## WEST SUSSEX COUNTY COUNCIL CONSULTATION

| <b>LOCATION:</b>                | Land South Of Littlehampton Road East of Worthing<br>Road Angmering BN12 6PN                                                                                                                                                                                                                                              |
| <b>SUBJECT:</b>                 | A/50/22/PL<br>Erection of 76 No. dwellings, means of access, public open space, play areas, associated infrastructure & landscaping (resubmission following A/168/21/PL). This application is a Departure from the Development plan, is in CIL Zone 5 and is CIL Liable as new dwellings & affects a Public Right of Way. |

**FULL APPLICATION
LARGE REFUSE
VEHICULAR TRACKING**

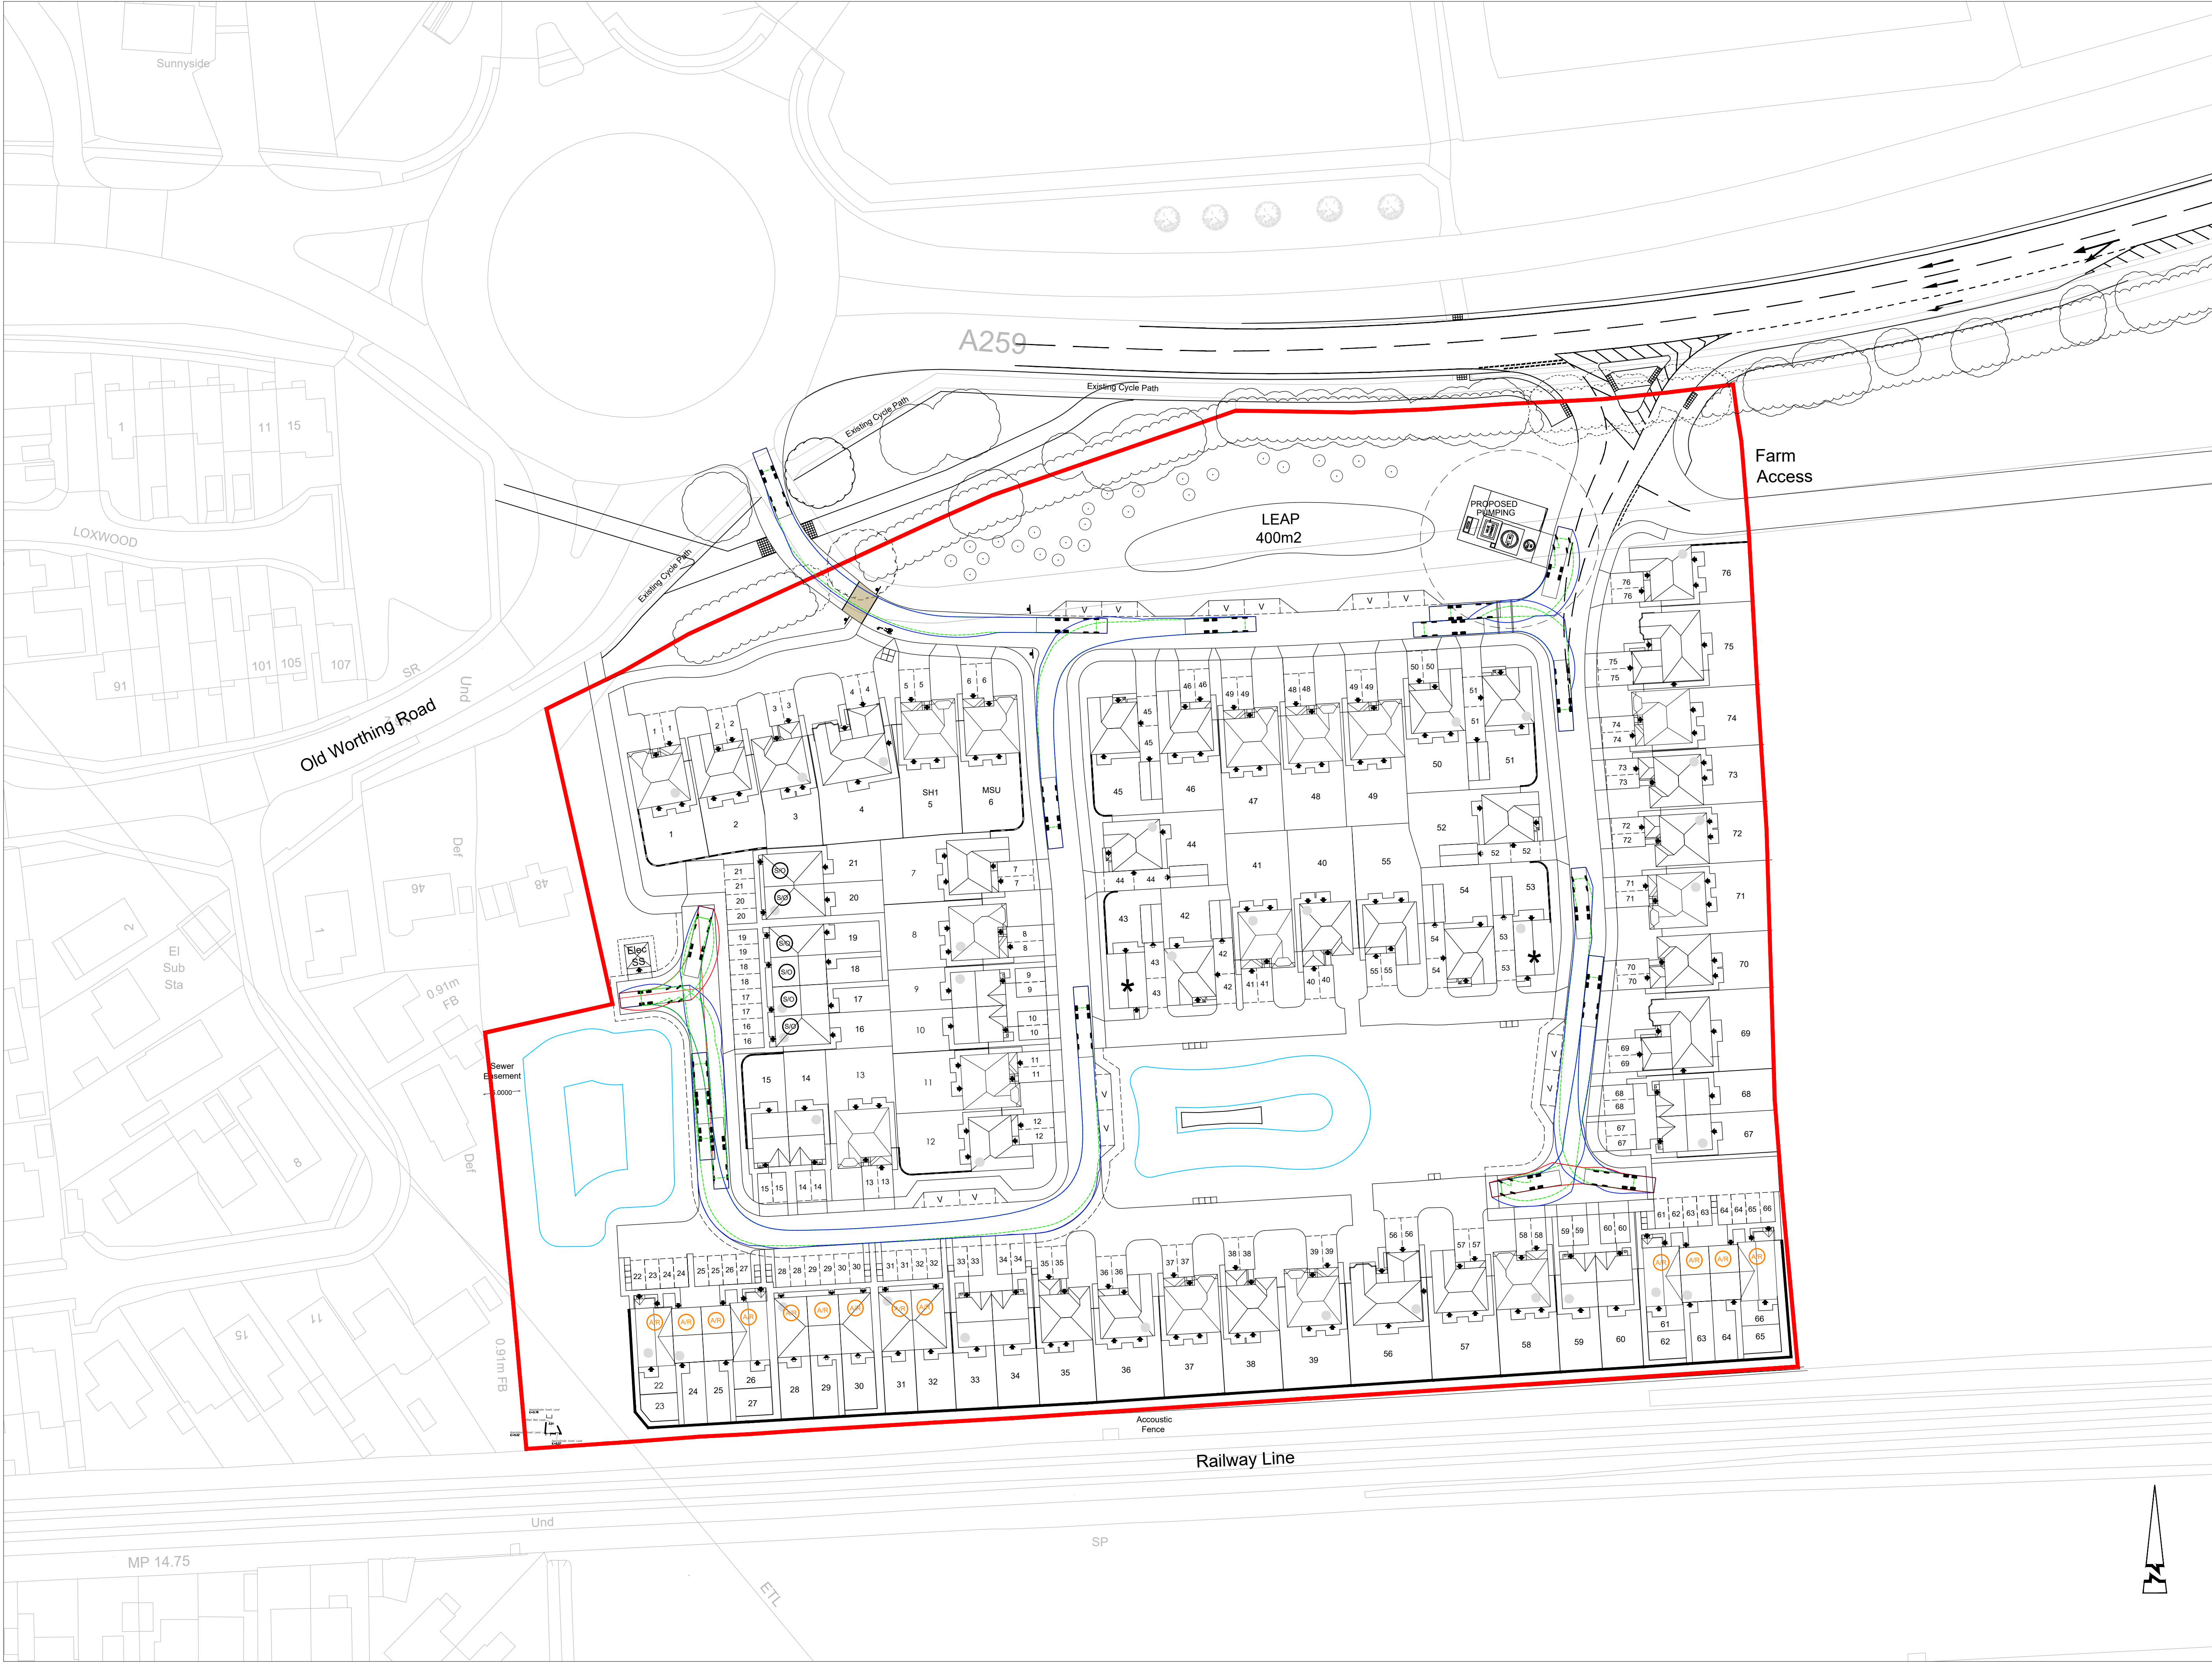
The internal layout has been designed in accordance with Manual for Streets design principles and provides access for refuse and emergency vehicles throughout the site; further detail of this, and the parking strategy, is in accordance with Arun District Council's parking policy.
